Planning Application Ref: BE/77/17/T

Location: Blackbirds, North Bersted Street, Bognor Regis

Description of works: 5m crown lift and 2m crown reduction to western side of 2 No Sycamores and 7m crown reduction to previous pruning points to 2 further Sycamores.

Blackbirds North Bersted Street PO22 9AH

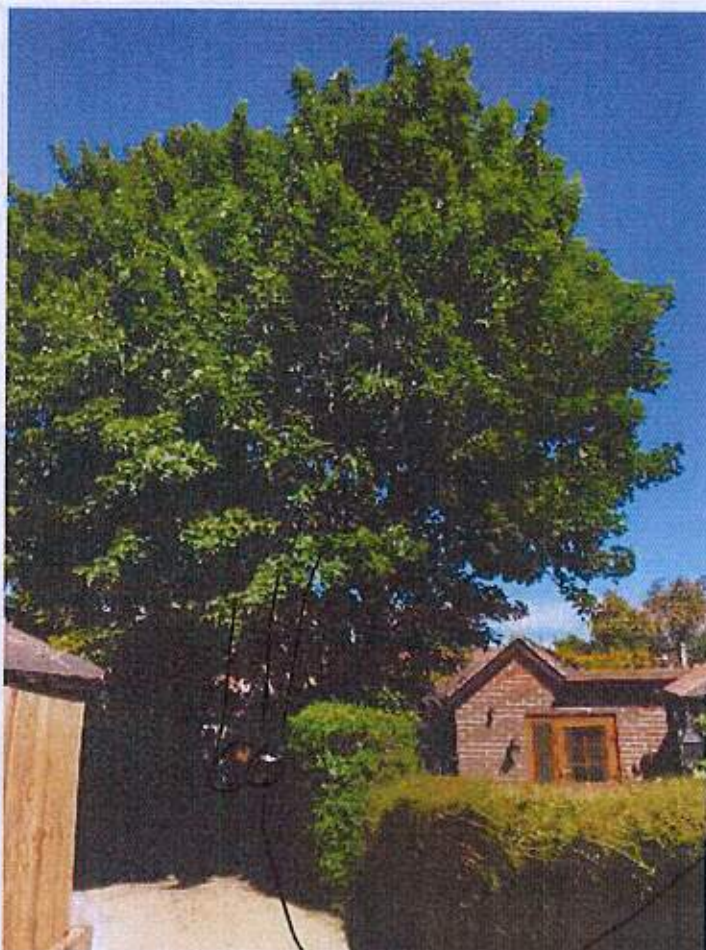
- Mature trees in good health and of good overall form but low branches are causing an issue with the nearby building.
- I would support some pruning work to keep these trees under control.

- Poor quality trees that have been heavily lopped and topped out in the past.
- I would support some major pruning works to keep the growth habit of these trees under control.

- The proposal to reduce the height and spread as listed in the application is reasonable and acceptable.

- Where whole branches are to be removed and final cuts made close to the trunk or branch union they are to be made as shown in Figure 2 of BS3998:2010
- Where branches are to be shortened back the final cuts are to be made at the correct angle shown in BS3998:2010 and adjacent to a live bud or lateral.
